## ASSESSMENT REPORT

### RESIDENTIAL SUBDIVISION AT 'BLACK ROCKS ESTATE', OVERALL DRIVE POTTSVILLE SECTION 96 MODIFICATION OF DEVELOPMENT CONSENT DA 243-10-2004

Title:
Subdivision Layout Plan
(DoP DA 243-10-2004)

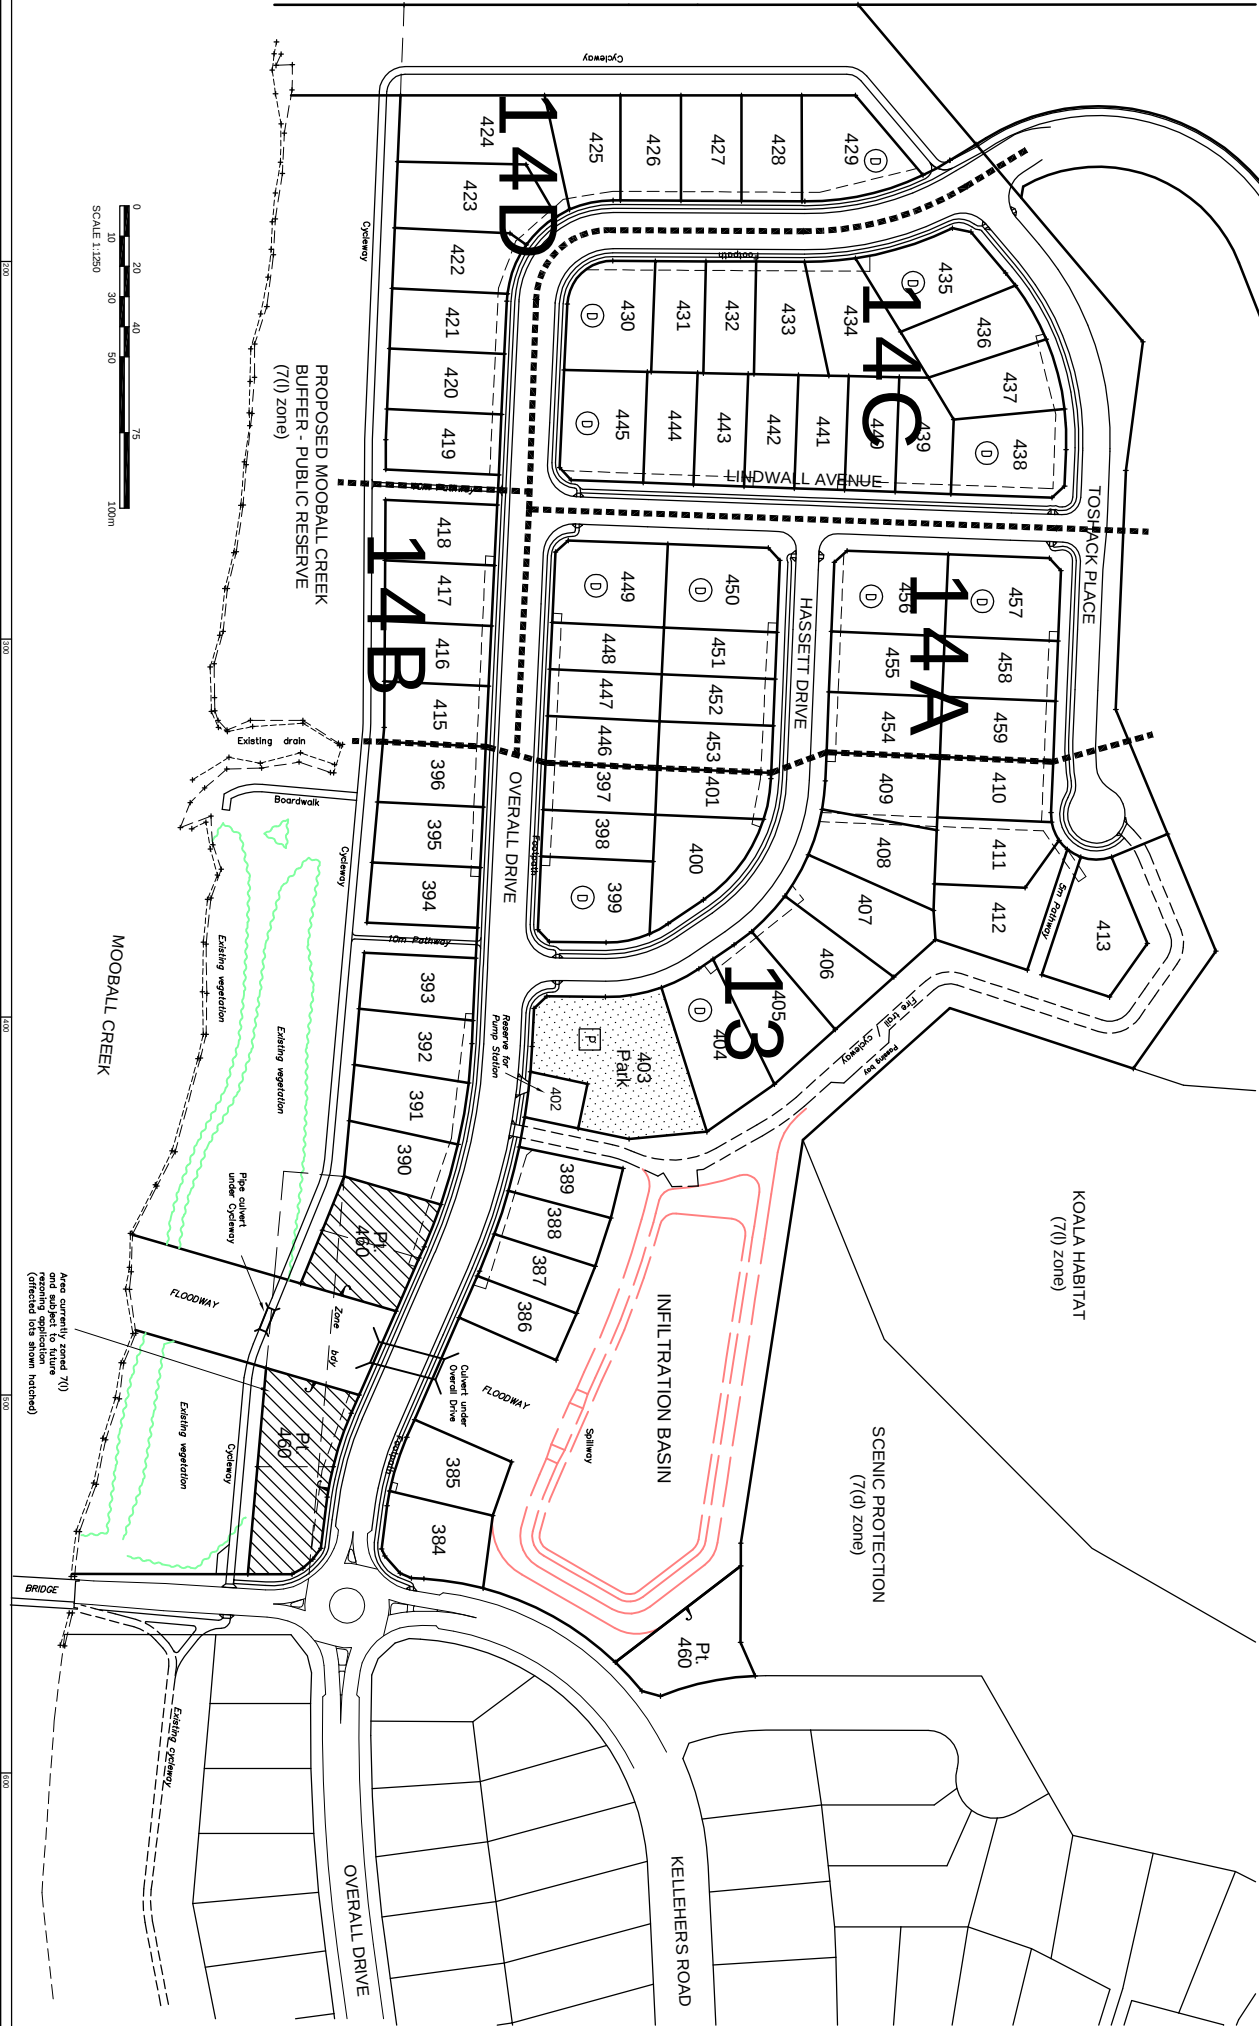
The original proposed staging plan submitted as part of Modification 5 created an additional residential allotment on the north-east portion of the subject site. Prior to lodgement of the subject modification, this lot formed part of the existing Lot 460 residual adjacent to the site's infiltration basin. In effect, the proposed staging plan (as lodged) created an additional residential allotment which could potentially create a number of complications on the site. As a result, this issue was raised with the applicant and on 15 January 2010 an amended staging plan was provided with corrected allotment detail corresponding with the existing approval.
